Our Case Number: ABP-313509-22

Re: BusConnects Belfield/Blackrock to City Centre Core Bus Corridor Scheme
Co. Dublin

**Re: BusConnects Dublin Core Bus Corridor – Route 14 (Belfield / Blackrock to City Centre'
Core Bus Corridor (CBC) Scheme
UCD Ballsbridge to City Centre Section
Route Option PR4**

**Figure 3.33: Route Option PR4 Indicative Scheme Design**

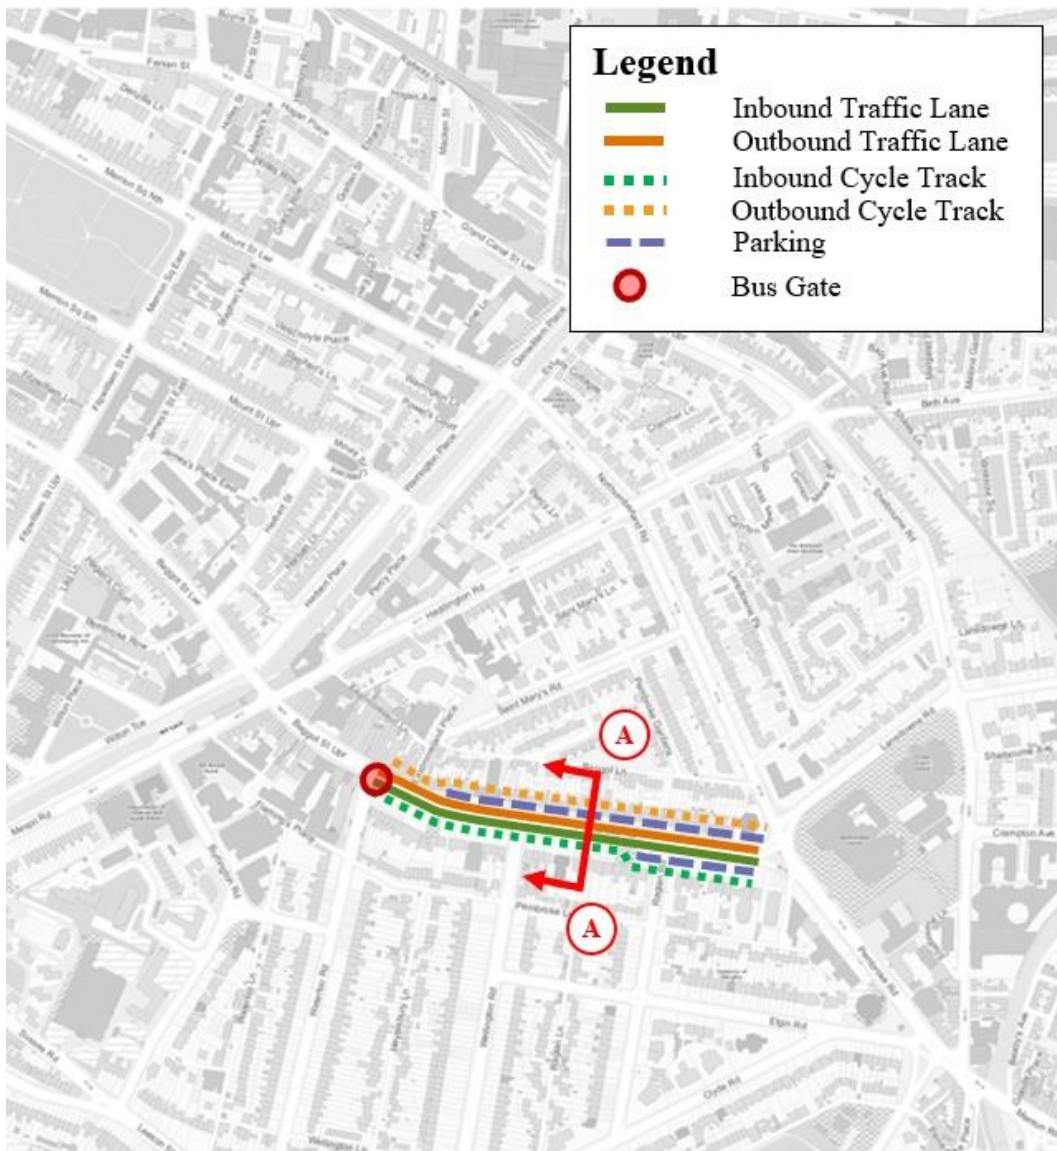
- Any proposal to stop traffic turning right from Mespil Road on to Upper Baggot Street will be severely detrimental to the local businesses on Upper Baggot Street;

- A situation where there is no through traffic from Upper Baggot Street to Pembroke Road will cut what is an existing vibrant community in two;
- It is ridiculous that there will be no / restricted parking in the Upper Baggot Street area – on street loading and parking are essential for this area;

- Turning a Georgian and Victorian streetscape into a bus corridor is vandalism at its most extreme;
- Cycle lanes on Haddington Road is a nonsense- when they are already running along the Canal;

- Cutting off access from Eastmoreland Place / St Mary's Road on to Upper Baggot Street further divides the community, and is illogical;
- Sending buses up Pembroke Road, cutting off car access from Ballsbridge/Jurys and Baggot Street, will cripple the local businesses in the Upper Baggot Street area; and

- Stopping parking on the Upper Baggot Street, will as a consequence push car demand to Waterloo Road, where there is already restricted parking Monday through to Saturday with the "priority" bus lane, and where there is inadequate parking available for residents and their visitors – local residents / businesses are being penalised unfairly.
